From: Maria Tomalova <Maria.Tomalova@arun.gov.uk>
Sent: Wednesday, September 13, 2023 5:29 PM
To: Planning.Responses <Planning.Responses@arun.gov.uk>
Subject: FW: Y/105/19/PL & Y/106/19/L

Y/105/19/PL & Y/106/19/L

The proposal is for the conversion of, and alterations to, existing barns to create 3 dwellings, along with the erection of car barns, a store, a replacement pump house, demolition of a C20 barn and associated landscaping and parking.

Drawing Title	Proposed Plans - Barn 3
Scale	1:100 @ A3

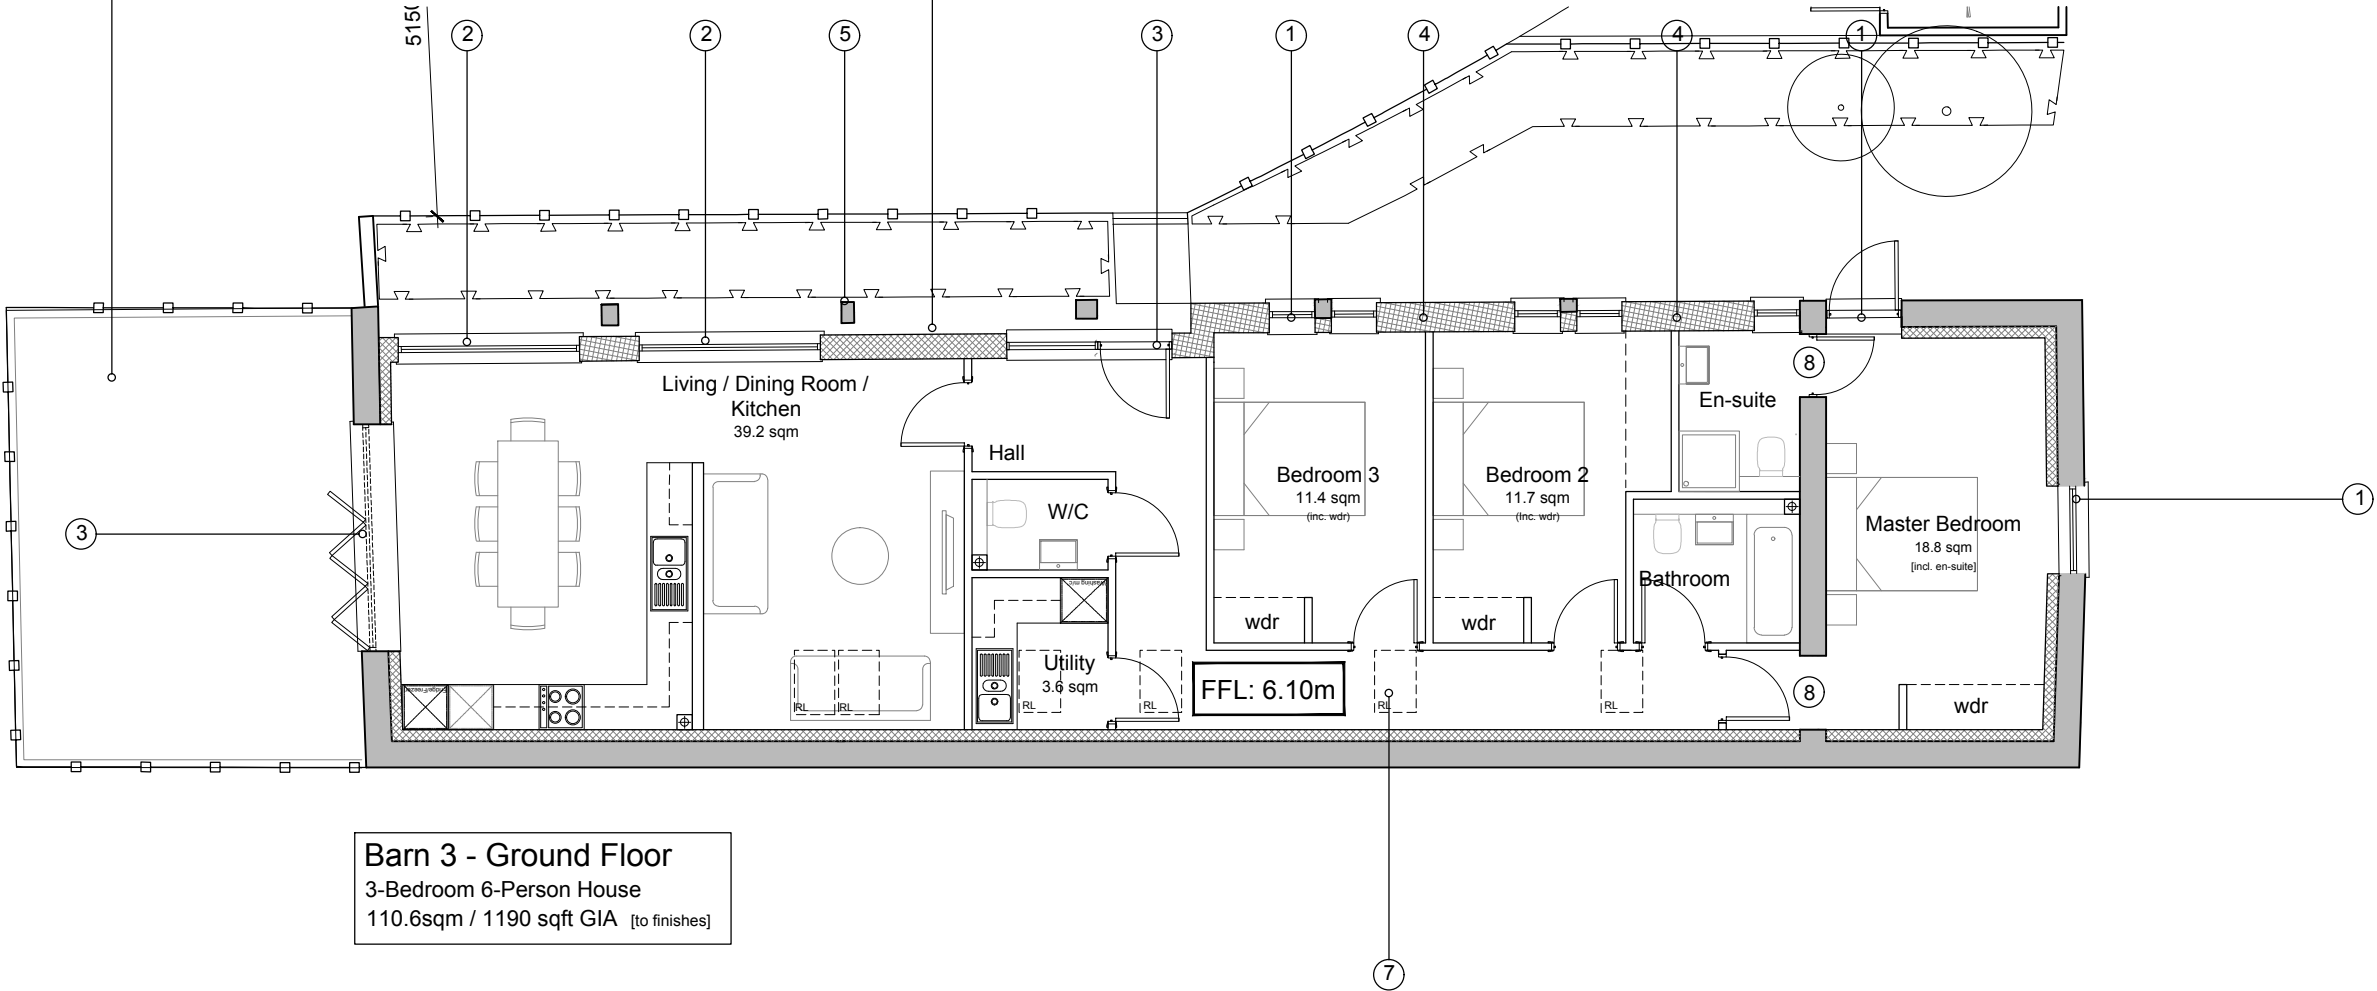
Likewise, it is noted that the building referred to as 'barn 3' is to include bi-folding doors. Such a feature is not normally associated with a barn and cannot be supported here. It is suggested that an alternative approach be considered which would result in the loss of less historic fabric, and a more appropriate design.

Yes, this can be altered to a pair of patio doors which will reduce the size of the opening in the exiting barn. Again, where new external openings are proposed we will look to repurpose the flint elsewhere in the scheme.
